Yorkshire Green Energy Enablement (GREEN) Project

**Document 8.21 Applicant's Comments on Interested Parties' Deadline
3 Submissions**

Table 2.1 – North Yorkshire Council: Comments on Additional Viewpoints [REP3-034]

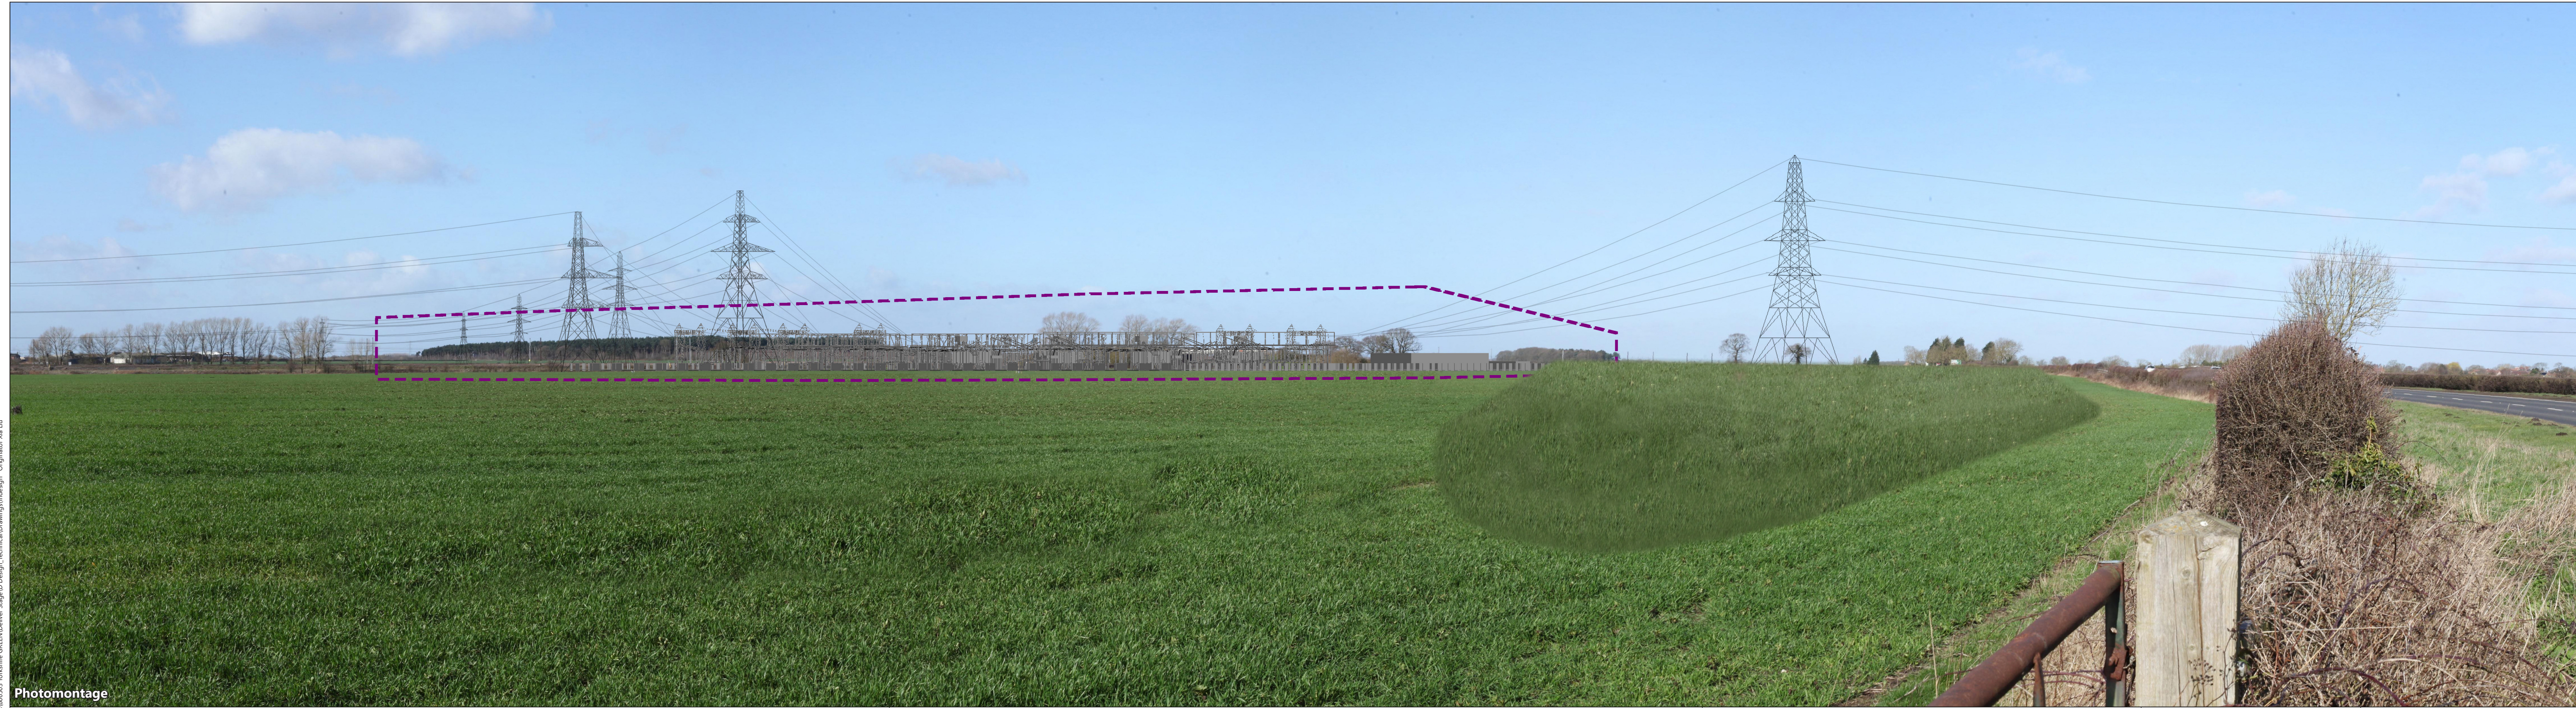
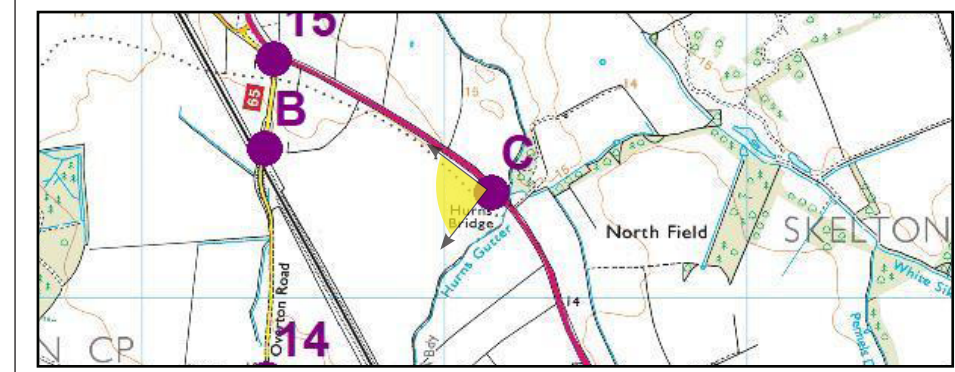
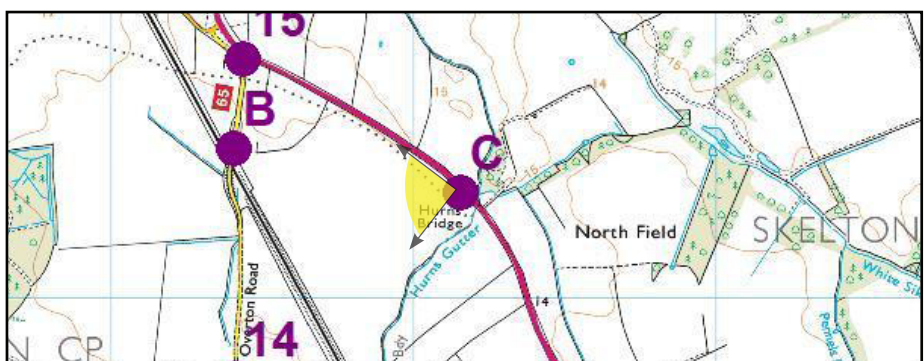
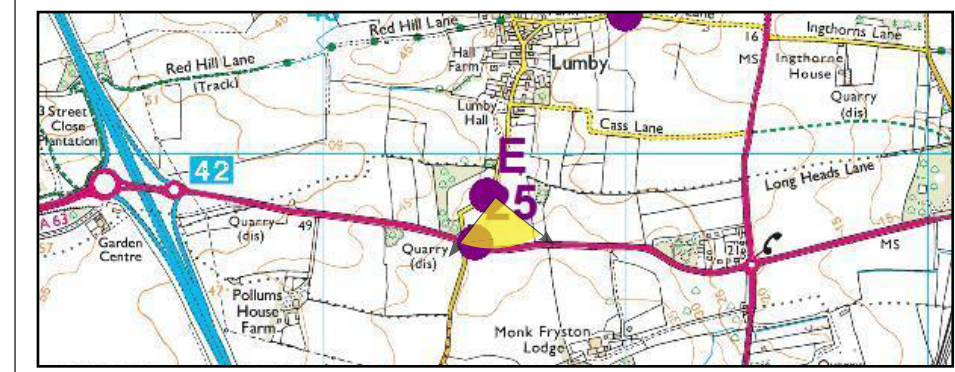
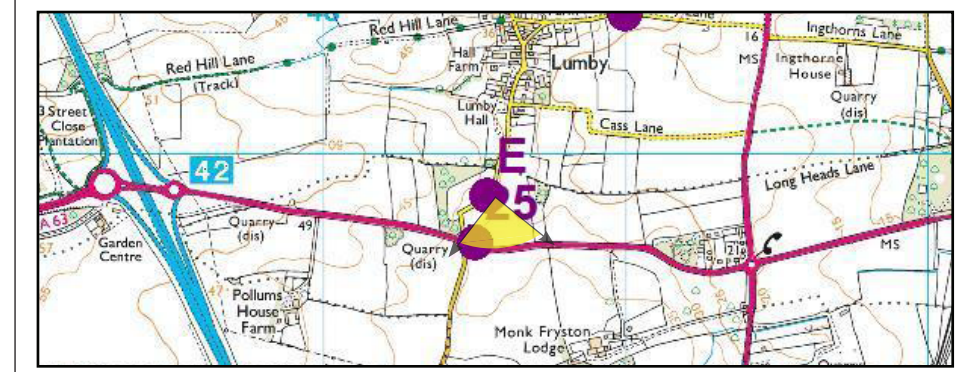
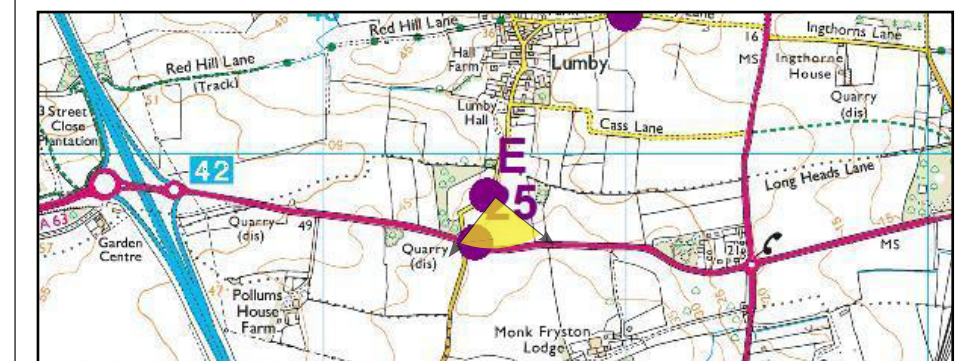
Reference	Issue Raised by NYC	Applicant’s Response
Viewpoints A, B, C and E	The insulators to the proposed overhead line tower structure have not been included on the photomontage.	<p>The purpose of the photomontages is to illustrate a reasonable approximation of the Project infrastructure, not a precise replication. In Section 8 of Table 2.3 of the Applicants comments on the Local Impact Reports (Document 8.10) [REP2-040] National Grid responded to NYC’s queries on the level of detail in the Type 3 photomontages. National Grid acknowledged the missing details on the photomontages including insulators, and some internal lattice work but not steel cross arms or substation structures. National Grid confirm this is not unusual at this stage of a project where full three-dimensional models of every infrastructure component are not designed in detail. Further detail was provided in the Applicants Appendix A response where it was stated:</p> <p>“National Grid consider that none of the omissions noted by NYC could have a bearing on the judgements made in the LVIA. Attention is drawn to paragraph 1.2.12 of Technical Guidance Note TGN 06/19 where the Landscape Institute states, “the degree of detail shown will typically be relative to the design and/or planning stage that has been reached” and at 1.2.13 “Two-dimensional visualisations, however detailed and sophisticated, can never fully substitute what people would see in reality. They should, therefore,</p>

be considered an approximation of the three-dimensional visual experiences that an observer might receive in the field.” In terms of Type 3 photomontages and photowires TGN06/19 states at 4.4.3 that: “Type 3 visualisations are intended to represent design, form and context to a reasonable degree of objectivity and accuracy, one which can be understood and relied on by competent authorities and others”.
Viewpoint E	The photomontages representing Year 0 and Year 15 do not appear to include the A63 (road) and low hedgerow at the northern edge of the road. These elements are north of the substation and it appears that the mounding has extended over the road and hedgerow. As a result the proposed mounding (and planting) appear closer to the viewpoint compared with the actual situation and this will have a bearing on the visual assessment judgements.	National Grid are not clear on the comments made by NYC and have attempted, without success, to obtain clarification. The proposed earthworks will be closer to the viewer than the existing earthworks/substation and require the removal of a hedgerow south of the A63 where it coincides with the proposed earthworks.
